Rezoning Transportation Analysis

Petition Number: 2022-133

Revision Log:

Date	Description
1-25-23	First Review (TM)
2-22-23	Second Review (TM)
04-26-23	Third Review (TM)

RZ-1.0

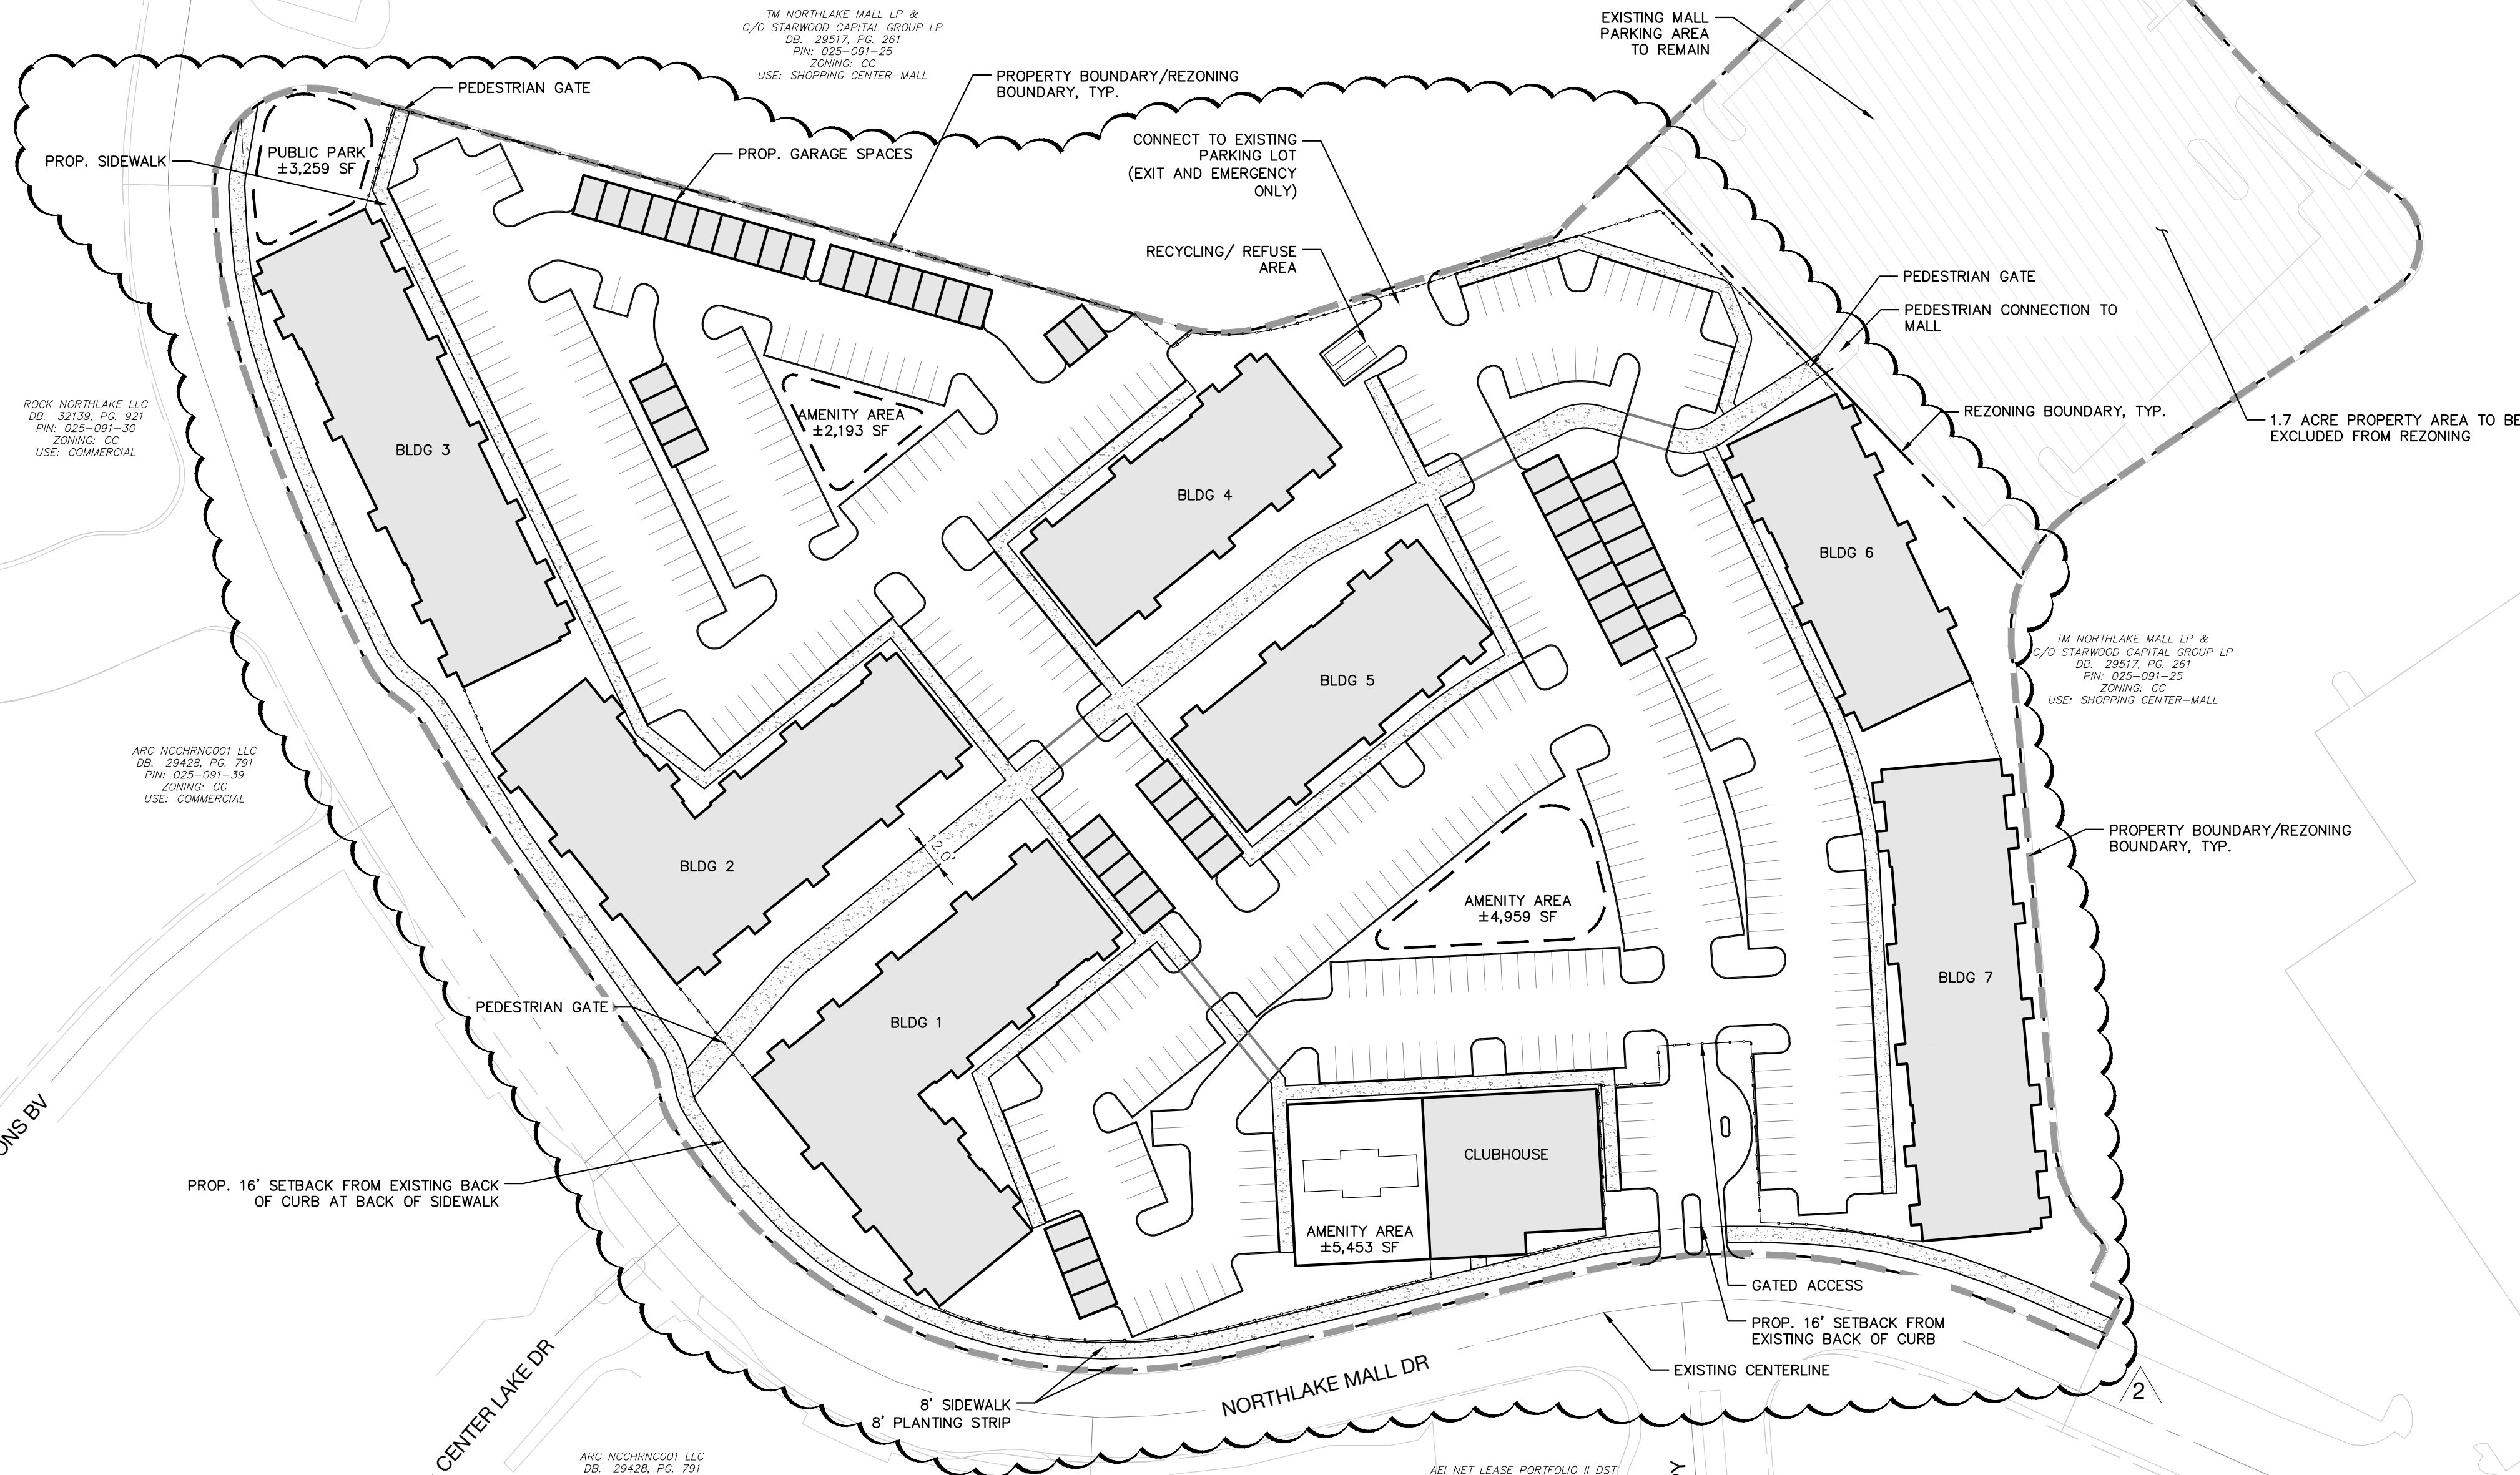
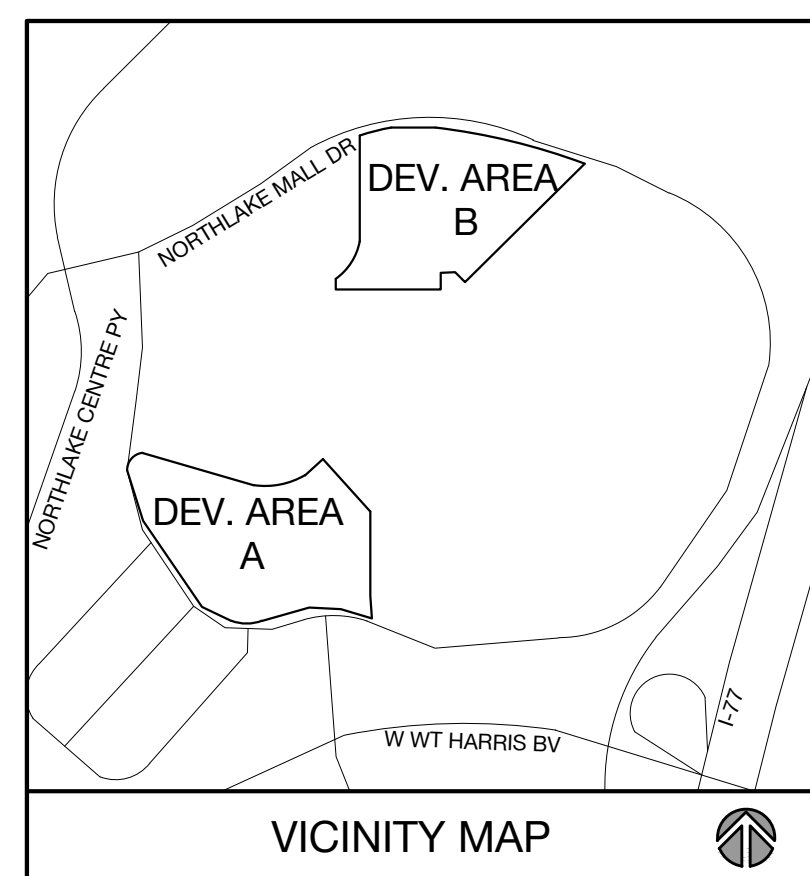
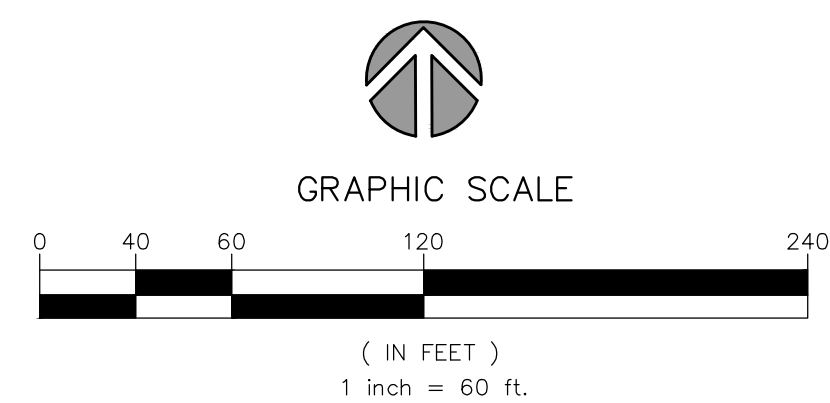
New Comment 04-26-2023: Site plan updates changed access location impacting both the TIS and the recommended improvements. Update or addendum to TIS required along with updated conditional notes to match TIS improvements.
